Town & Country Planning Act 1990 (as amended)
Town & Country Planning (Development Management Procedure) (England) Order 2015

New entrance/driveway, restoration of external building at the front of the property.
Restoration of walled garden, front and rear. Adjustment of levels around the property.
Restoration of all windows and small front porch area. Two storey extension including
demolition of existing extension. This application may affect the character and
appearance of the Lyminster Conservation area.

Lyminster Cottage Lyminster Road Lyminster

FIG A.

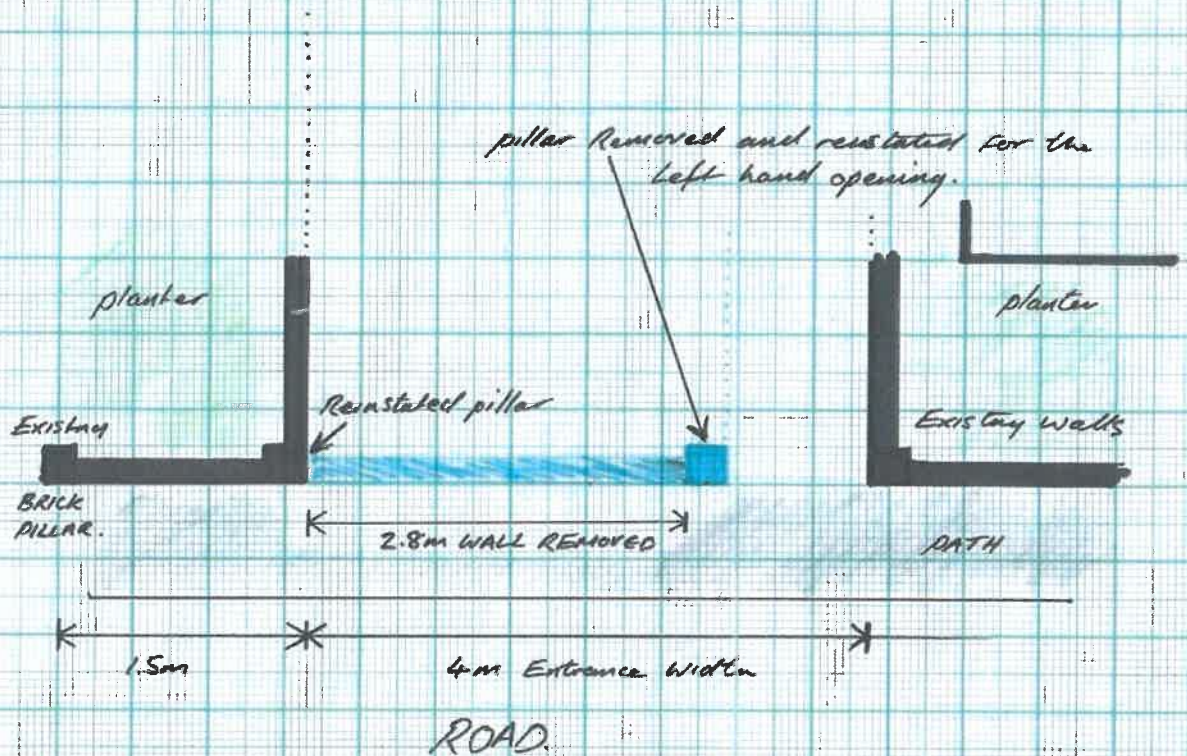
*Lyminster Cottage is a Grade 2 Listed Building which together with the front boundary
walling makes a positive contribution to the character and appearance of the conservation
area.*

*The significance of this part of the conservation area lies in its semi-rural character formed
by the informal pattern of space and buildings of varying age, size and form. An important
contribution to the significance also lies in the extent of front boundary flint walling which is
visually attractive and also forms a unifying feature in the street scene. The loss of flint
walling is always regrettable, not only through its age but also because it can be rarely
reproduced to the same quality of construction or appearance and as such tends to be a
finite resource.*

*The Panel fully appreciate the positive aims and aspirations of the applicant towards the
improvement of the building as indicated in the Heritage Statement. However, the Panel's
remit is to consider the effect of the proposals on the conservation area. As such it
considers that to permit the removal of a significant section of the front boundary walling to
form a vehicular access will detract from the character and appearance of the
conservation area and also the setting of the Listed Building. It could also set a precedent
for similar detracting proposals elsewhere in the historic environment of the District where
historic buildings lacking vehicular access is not a rare feature.*
